Address: 4 Bankfield Drive Holmfirth hd9 2ph

Application number: 2023/91212	
What is the application for?:	Erection of 21 dwellings with access from Laithe Avenue
Address of the site or building:	Land off, Bankfield Drive, Holmbridge, Holmfirth, HD9 2PH
Postcode:

Type of comment: An objection	
Do you wish your comments to be published on the website anonymously?	No
<p>As well as an objection previously submitted citing highways I also object to the plans for the development on the following grounds:</p> <p>Drainage There are already a number of drainage issues connected to the current estate which have resulted in subsidence to roads and sewage escapes into the River Holme below. Significant volumes of surface water from the field run onto Dobb Top Road already, potentially weakening the high dry stone retaining wall bordering the north of the site. Development of this field could compromise the structural stability of the wall still further and, should it collapse, the knock on affect to the properties on Smithy Lane would be cataastrophic. Appropriate disposal of surface water has not been addressed on the plans submitted. The comments of Kirklees Lead Local Flood Authority dat

Date:	21.01.21	Project:	Bankfield Drive, Holmebridge
Scale @ A3:	1:500	Drawing Number:	2021.01.003
Drawn By:	CD	Revision:	V

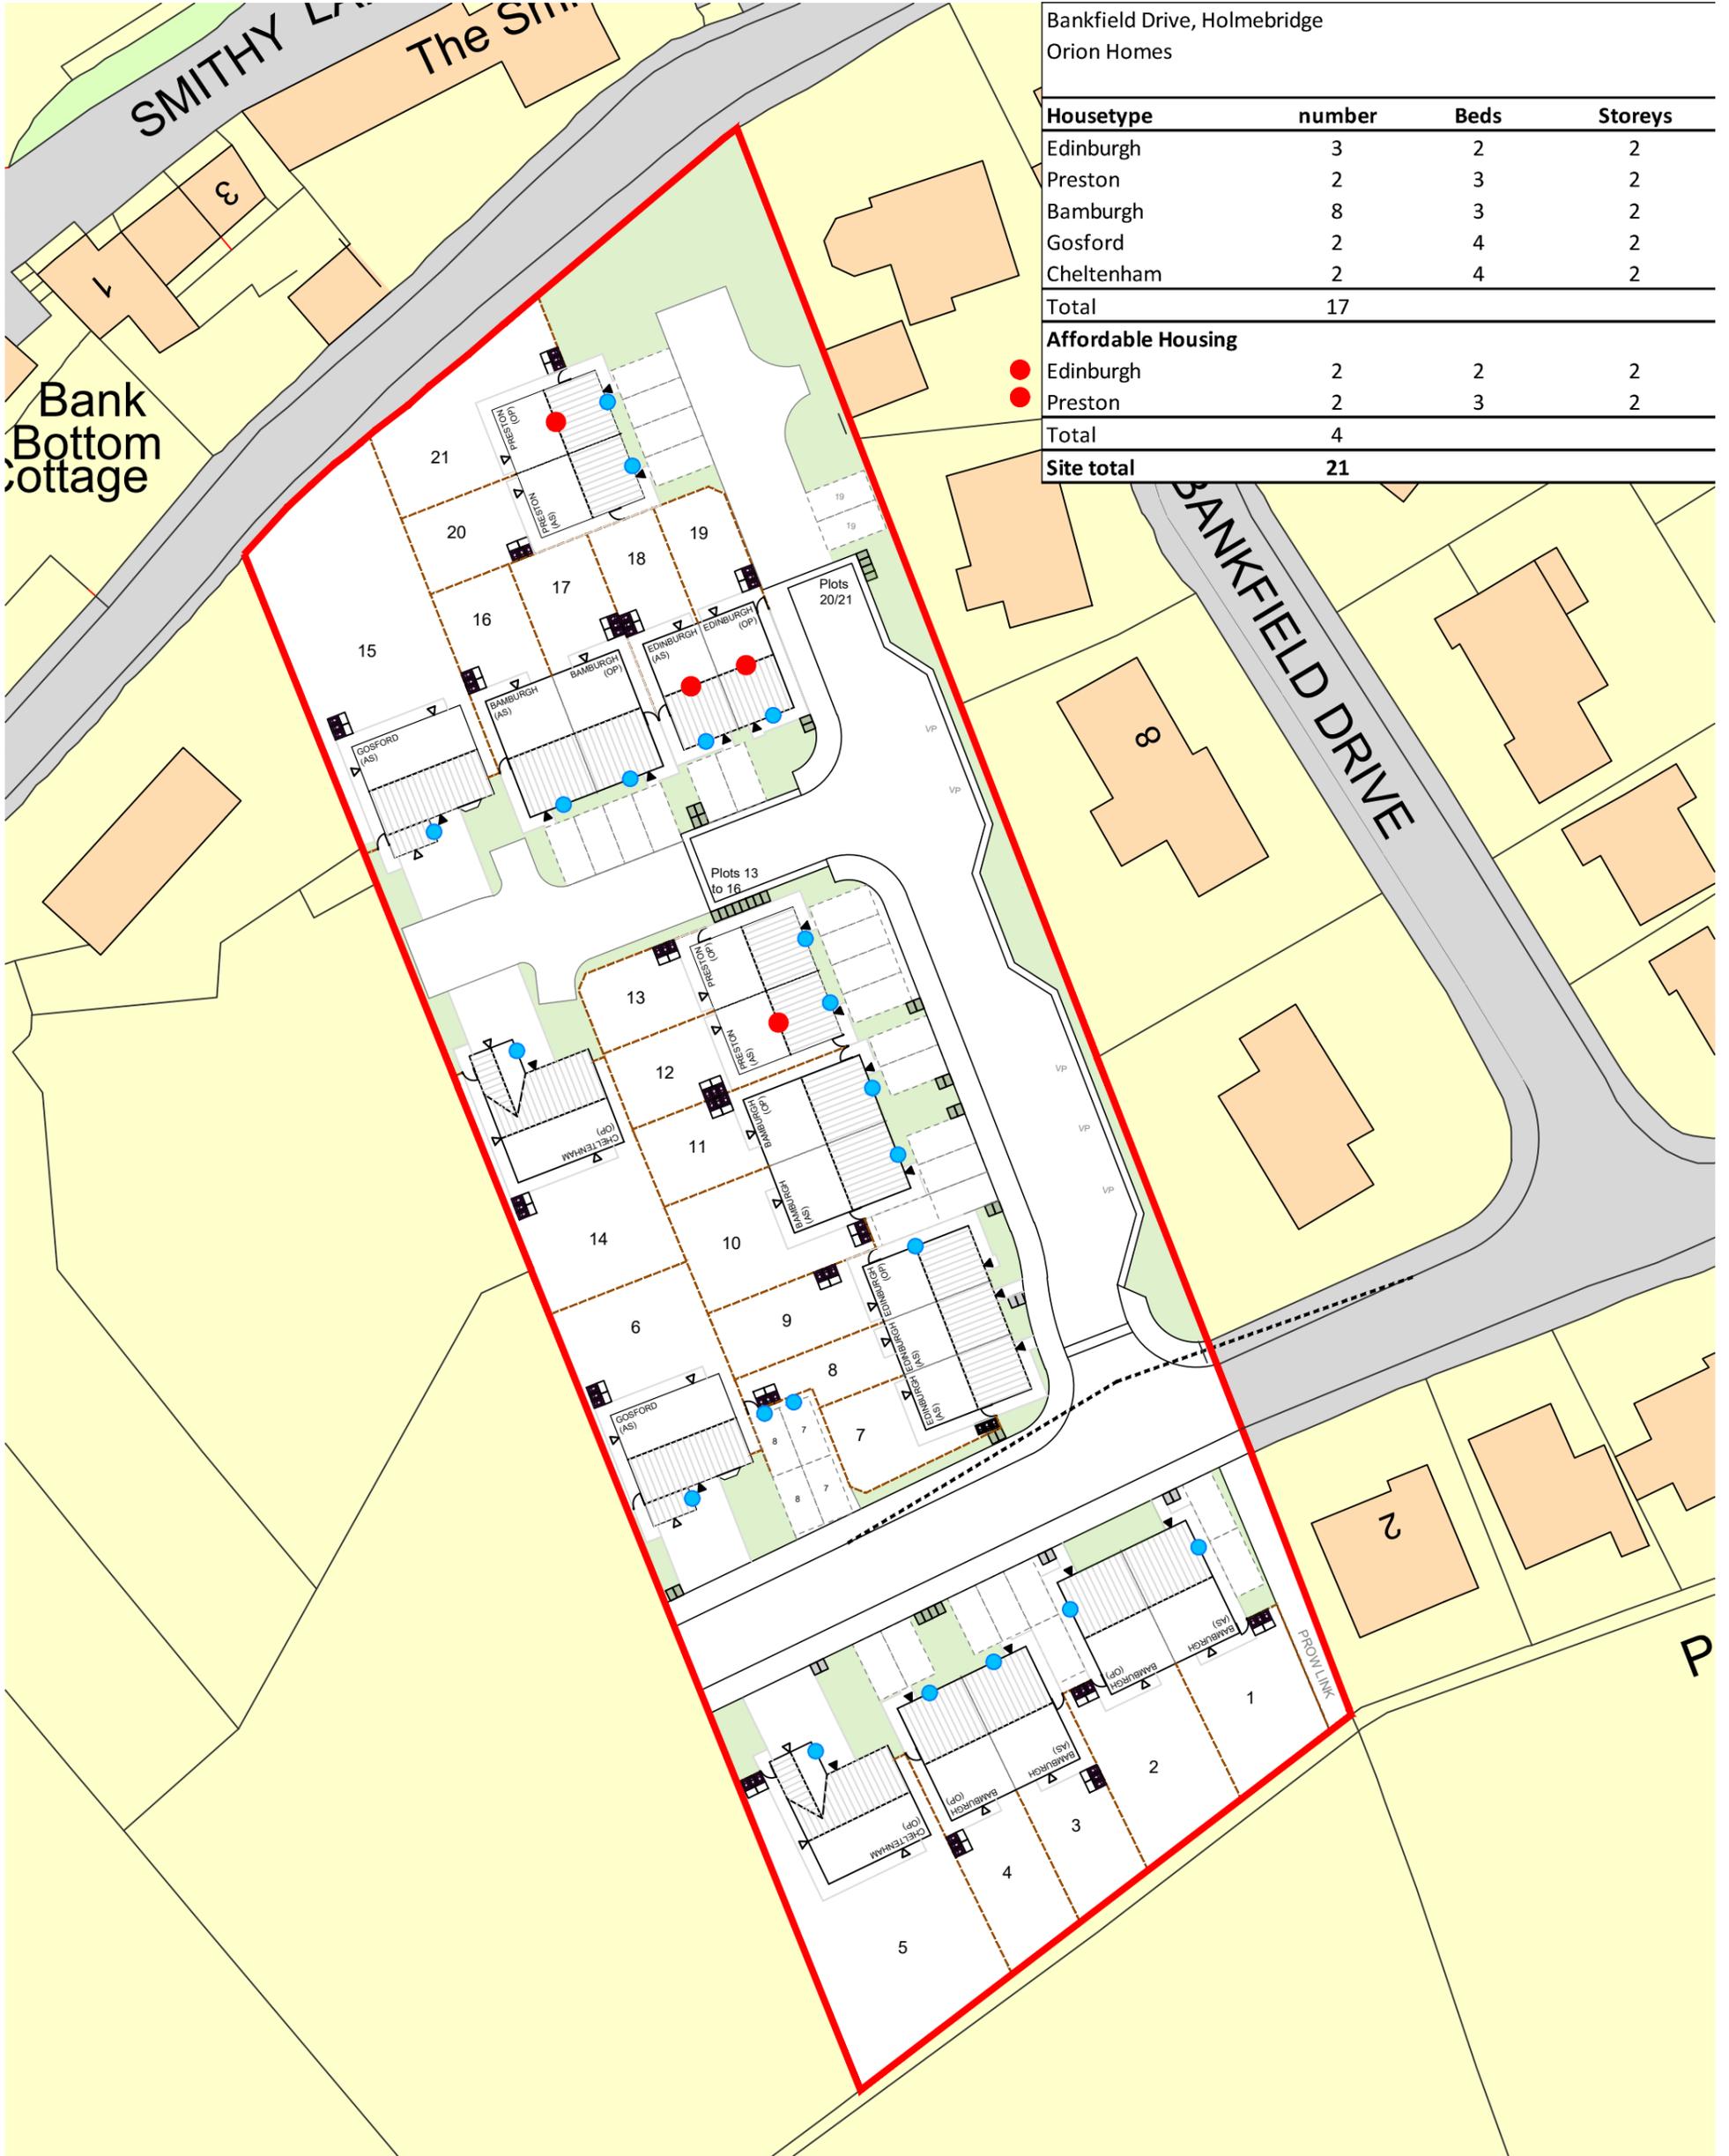
planted areas as well as there being wholly inadequate screening to existing properties. The suggested new native hedge being even lower than the low dry stone wall we assume it will sit in front of. Subsequent ownership and maintenance responsibility for said wall has also not been supplied despite repeated requests.

On the Kirklees Council Strategic Housing consultation response dated 31st May 2023 it states 'affordable homes should be distributed evenly throughout the development'. In a further response dated 24th October 2023 they state 'affordable dwellings should be well integrated within the site layout and not located at specific areas at the edges of sites'. Four affordable homes are designated for this site on the revised plan. Three out of the four are located at the north east of the site. This is not 'even distribution'. It also contravenes 'Kirklees Affordable Housing and Housing Mix' document Section 6 dated March 2023 as well as national planning policy guidelines.
